Two storey rear extension. Gable extension to front to include 2 balconies. Re-submission following FP/6/11/

Seacroft Outram Road Felpham Bognor Regis

I regret that I am unable to accept your documents as a formal application until the following matters have been resolved :-

Proposed Side Elevation

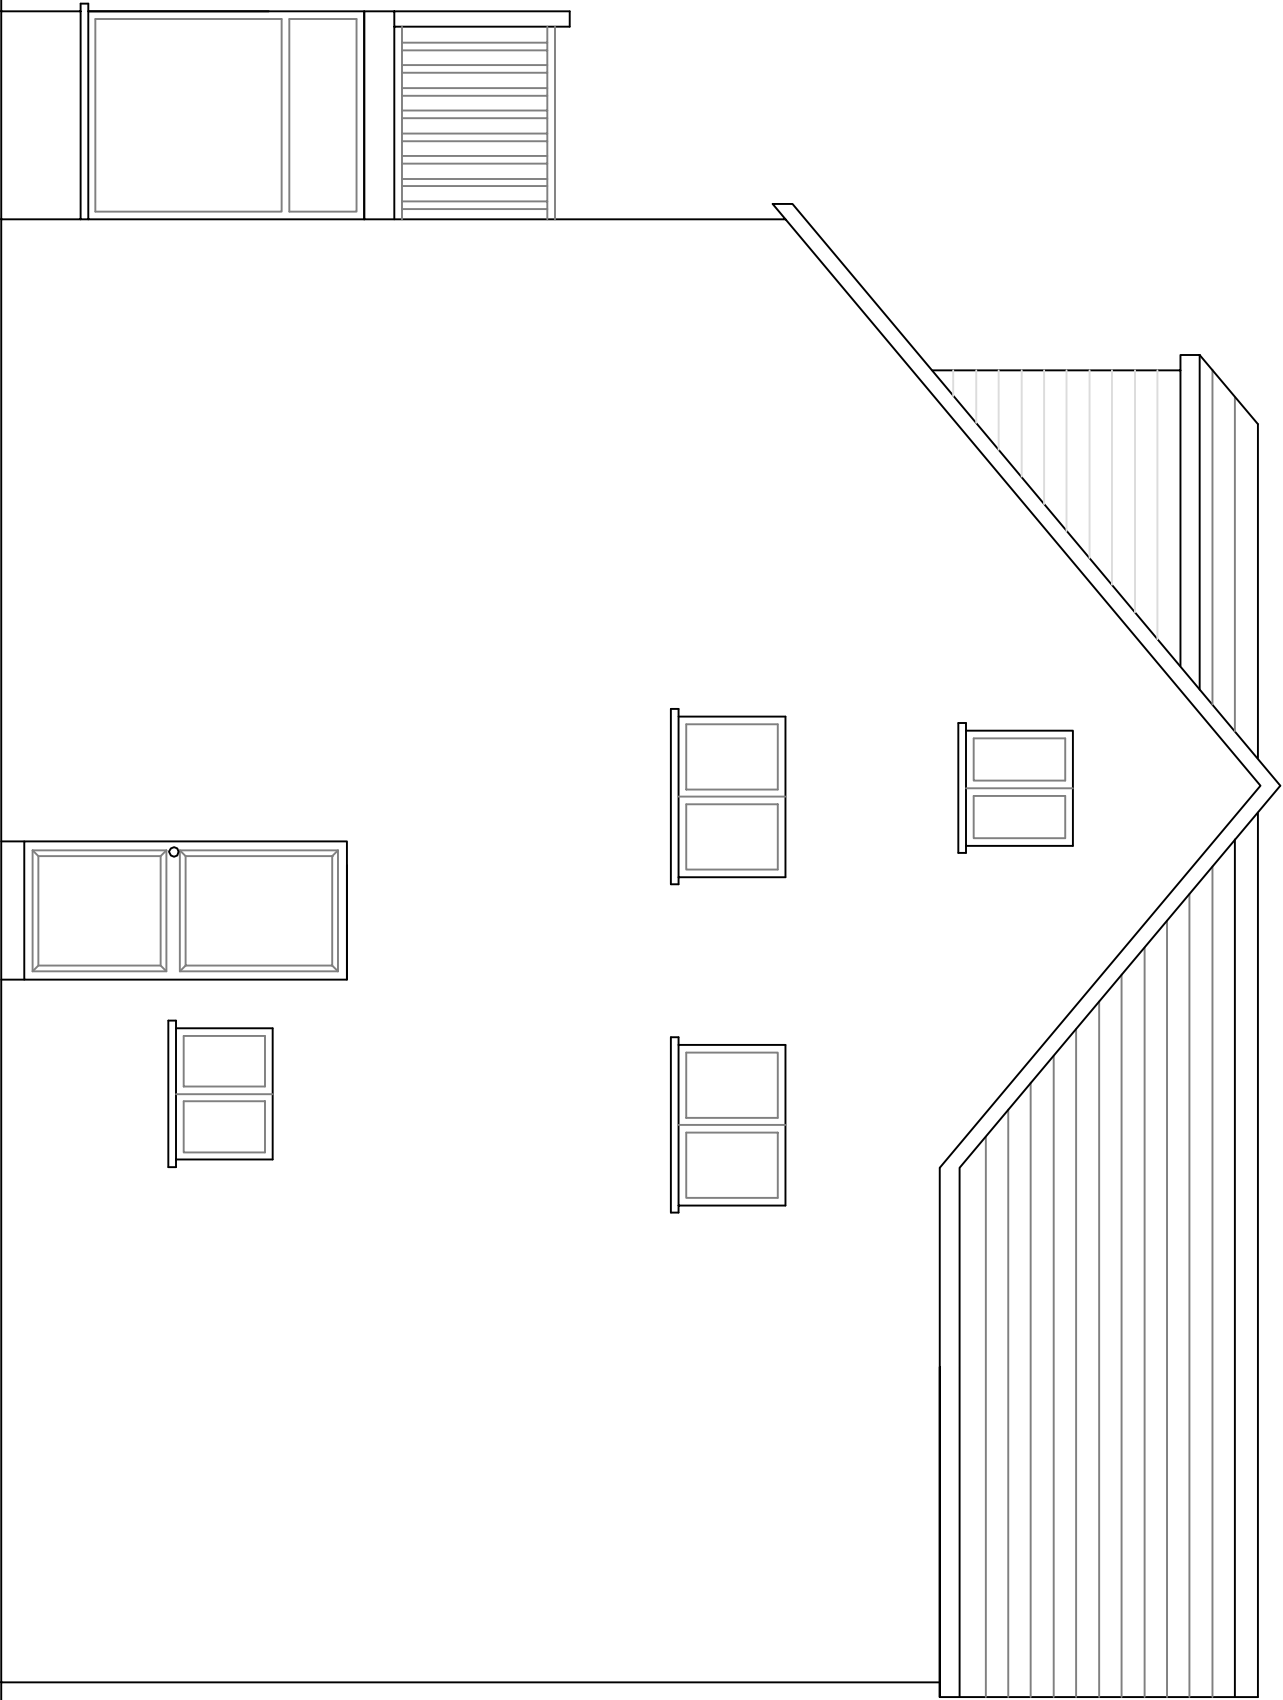
Please provide 1 electronic or 3 paper copies of a proposed ground floor plan and a revised proposed second floor plan to show the window detailed on the proposed side elevation.

Item ref	Quantity	Title/Name, designation, material, dimension etc			Article No./Reference
Designed by	Checked by	Approved by - date	File name	Date	Scale
JD				Sept 2010	1:200

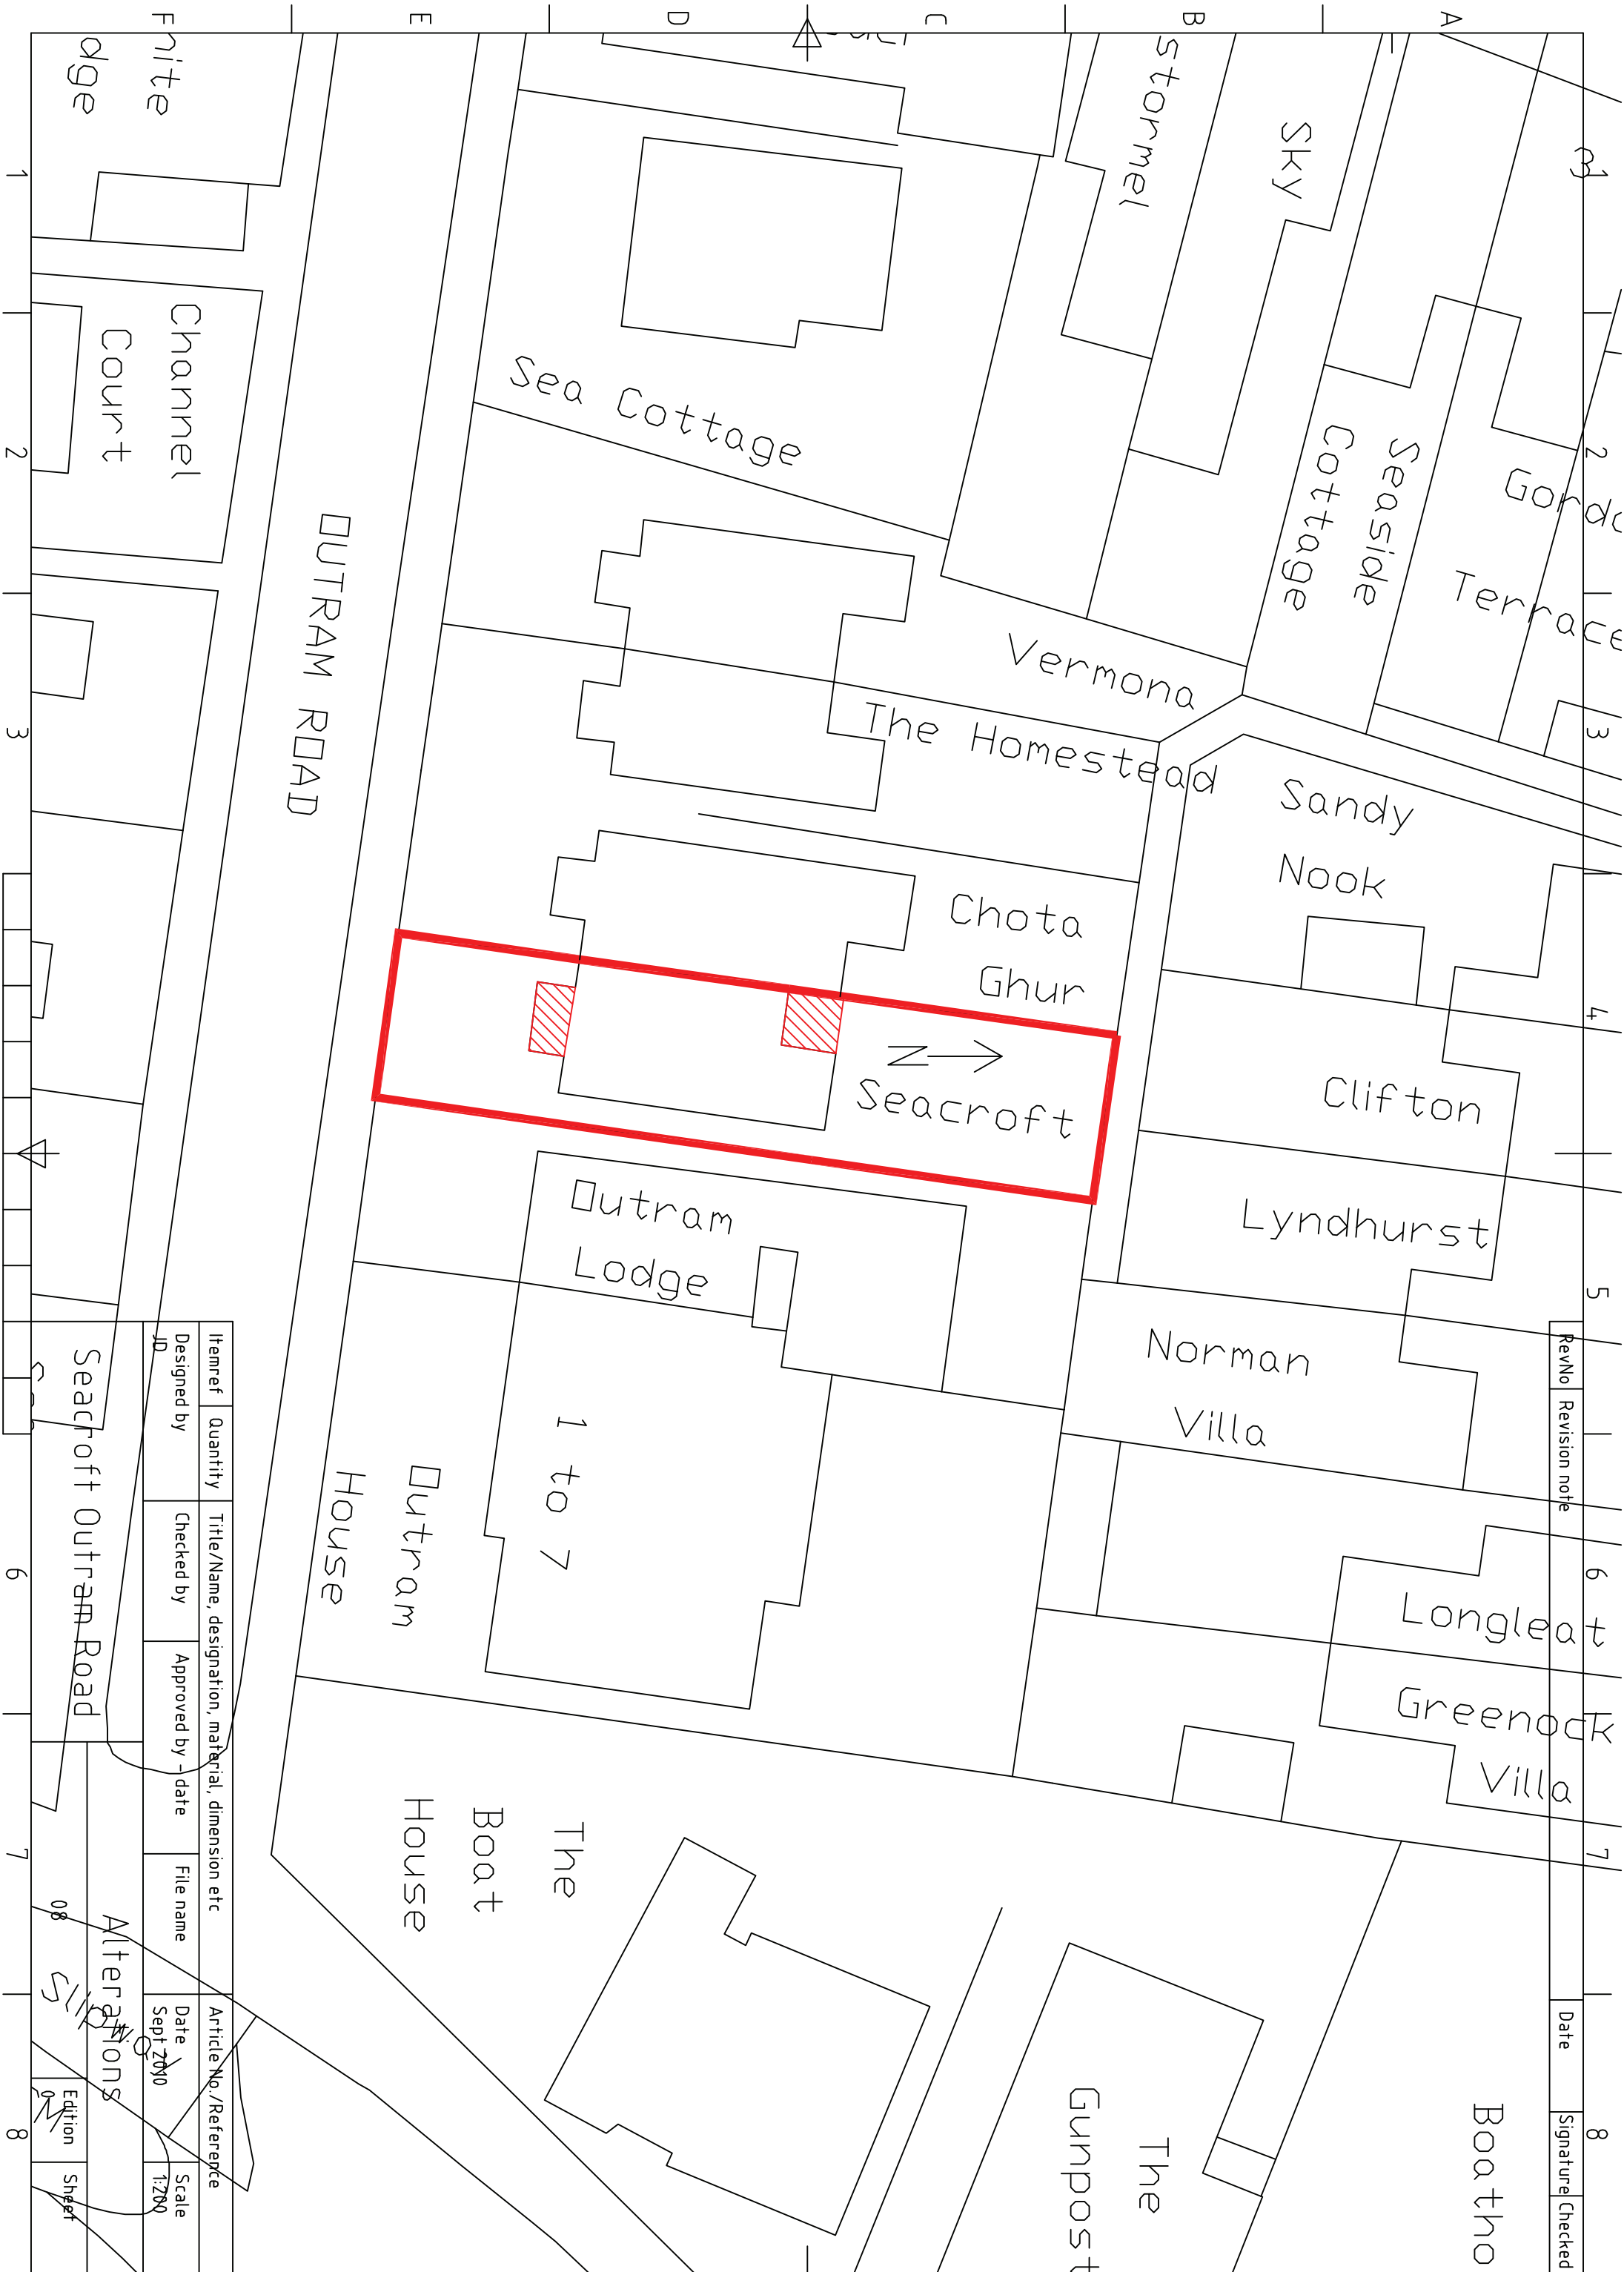
I require 1 electronic or 3 paper copies of revised block/site plans (1:500 and 1:200) to show the proposed works on the front elevation as well as the rear, in accordance with the guidance notes available on our website detailed below (click on National List).
